re: **Geotechnical Response to City Comments**
Proposed Daycare Center
2826 Springland Drive - Ottawa

date: July 16, 2019

file: PG4883-MEMO.01

Paterson Group (Paterson) prepared the following memo to provide our responses to the geotechnical-related comments issued in the letter dated July 11, 2019 prepared by John Bernier at the City of Ottawa.

1 GRADING PLAN  
C1 SCALE= 1:200

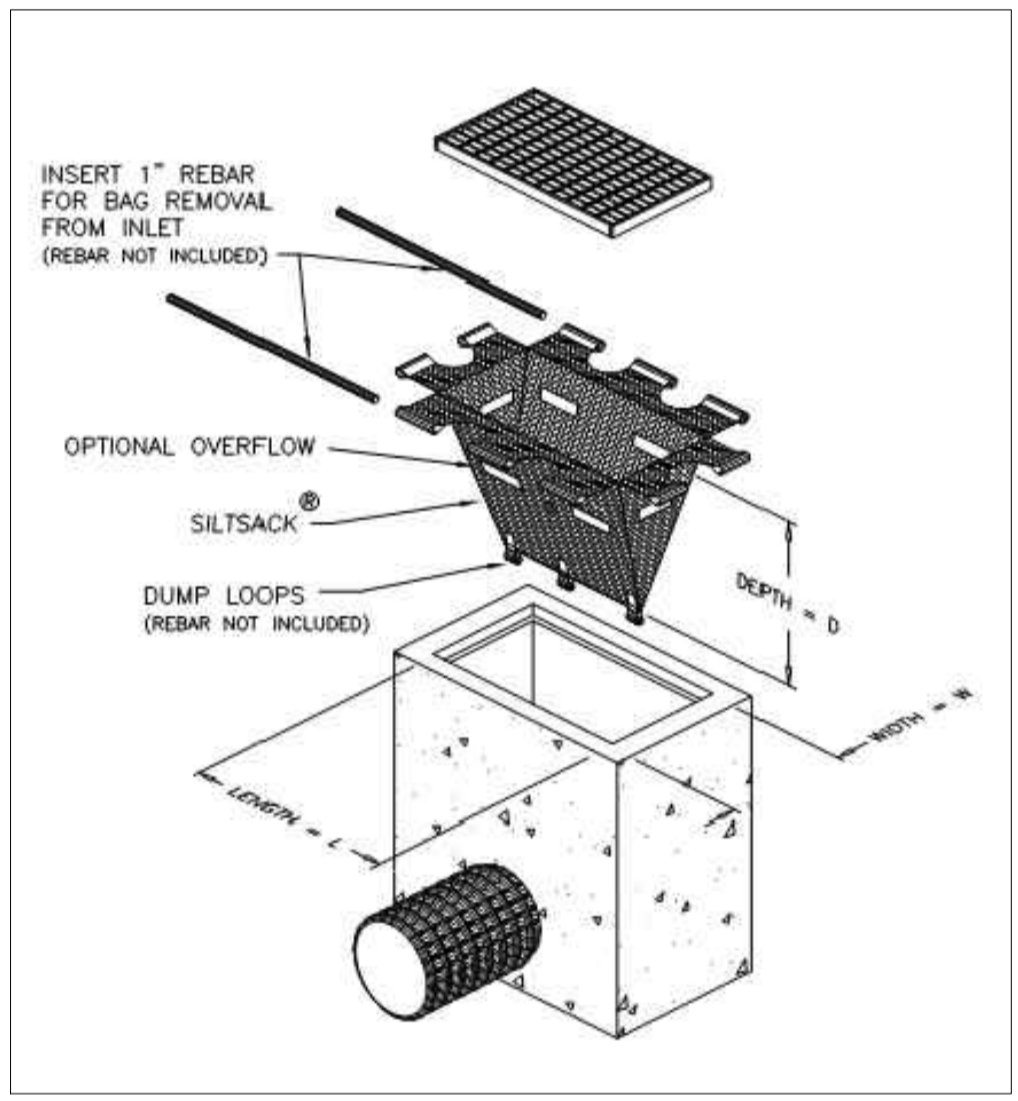
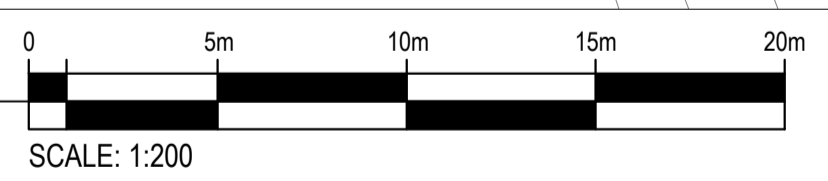
Comment: *Provide letter of confirmation that associated grading plan has been reviewed and is acceptable with regards to geotechnical requirements.*

Response: Paterson reviewed the following grading plan prepared by WSP for the aforementioned development:

- Grading Plan - Sediment Erosion Control, Drawing C1, Project 191-03236-00, dated 2019-03-22, revision 1, dated 2019-05-10.

The grading plan has been reviewed and is considered acceptable with regards to the geotechnical requirements of this project.
